Consultation Response from KC, Highways Development Management
2024/93227 land at, St Luke's, Bierley Marsh, East Bierley, BD4 6PL
Variation condition 2 (plans) on previous permission 2020/94345 (APP/Z4718/W/21/3289729) for erection of 5 dwellings
Date Responded: 6-5-2025. Responding Officer: Mark Berry Responding Ref: 8-8SE-10.

Further to the highways consultation response dated 29th January, the applicants have now provided revised plans 104 F and MCB/24/018/0701 showing generally acceptable proposals.

Project	STANDARD DETAILS		Scale	1:20
	Commercial Regulatory and Operational Service Highway Design Flint Street, Fartown Huddersfield, HD1 6LG	Title RAMP DETAIL CROSS SECTION B - B	Drawn	MWN	Checked
Section			HD	Date	MAY 2022
Drawing No.			HD-SD-07-17A

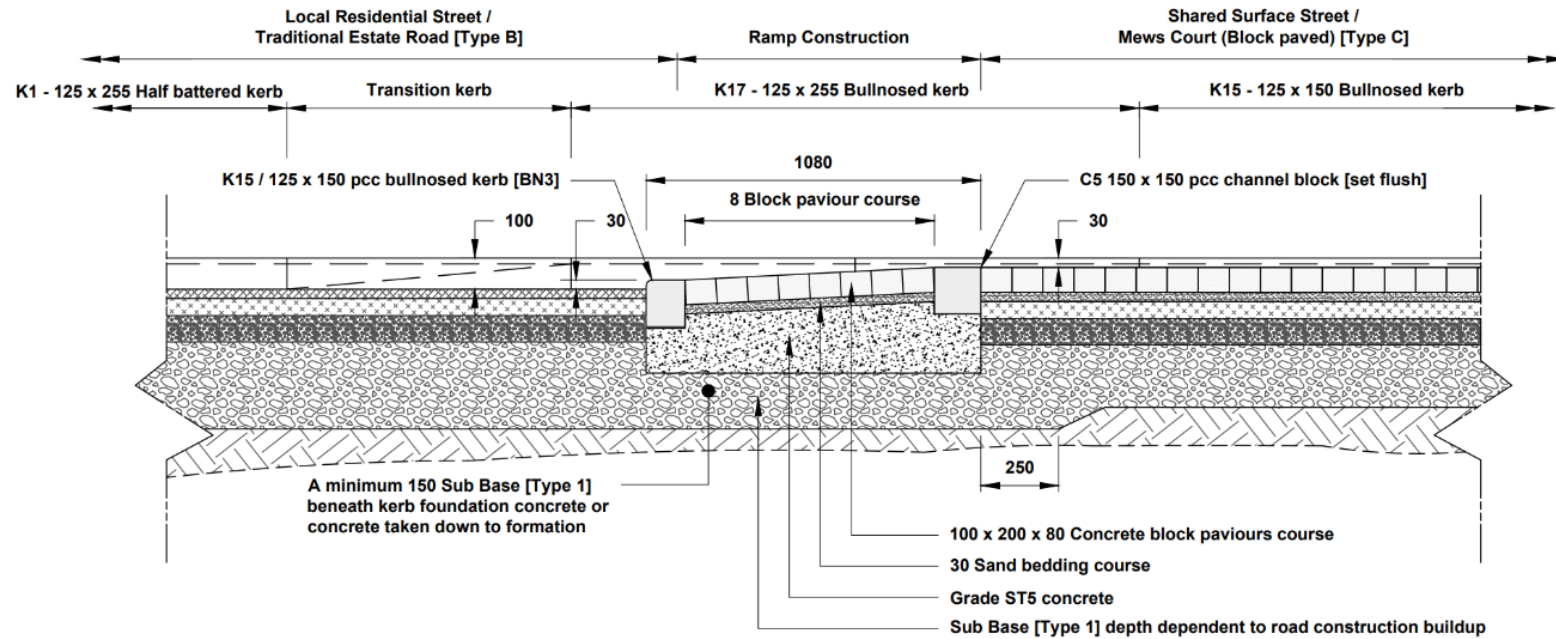
Highways Development Management would however recommend that the ramp at the site entrance (coloured brown on the MCB plan) is omitted as this is not needed.

Project	<h1>STANDARD DETAILS</h1>		Scale	1:20	
	Commercial Regulatory and Operational Service Highway Design Flint Street, Fartown Huddersfield, HD1 6LG			Title	<h2>CARRIAGEWAY TIE-IN SECTION C-C</h2>	Drawn
Section		HD	Date			MAY 2022
Drawing No.		HD-SD-07-18A

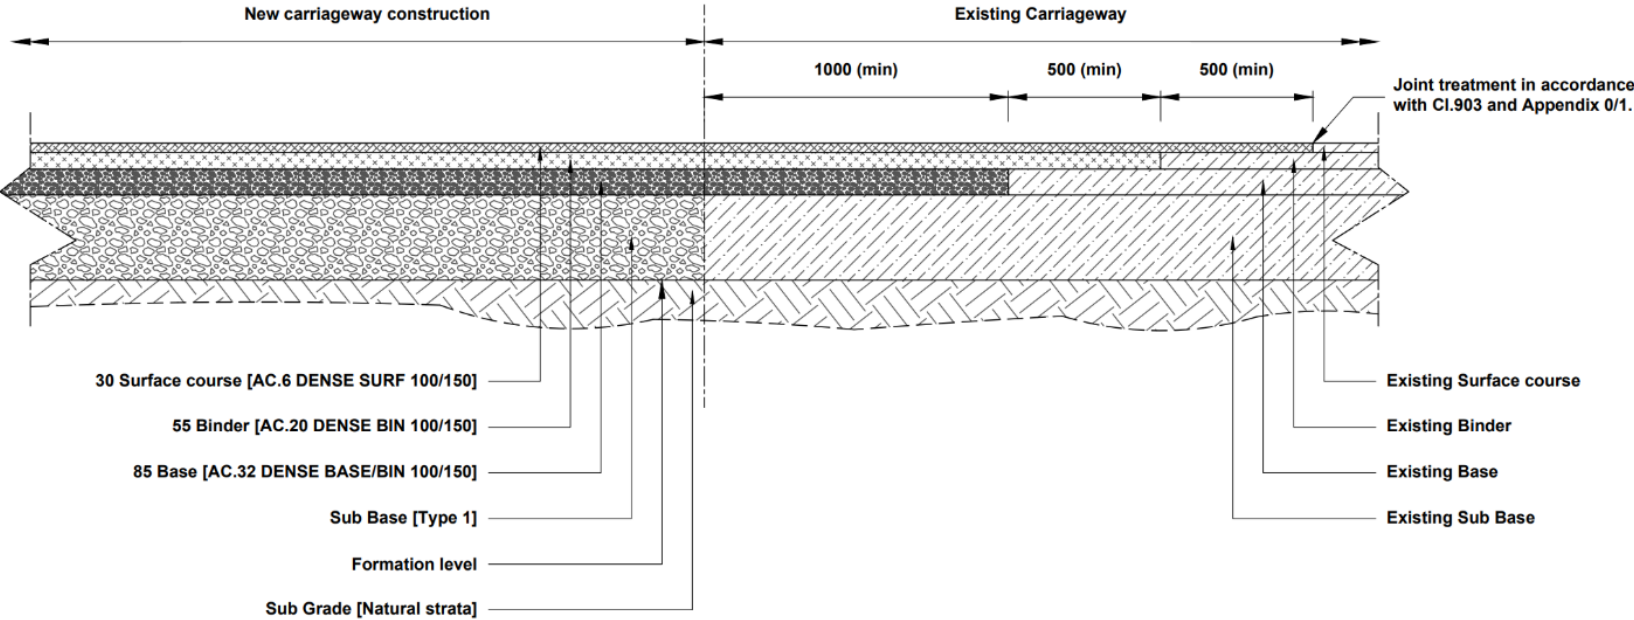
The tie in between the widened section of Bierley Marsh and the existing (shown yellow and cross hatched with solid and dashed lines on the MCB plan) should be tarmac and not topsoil and seed as shown.
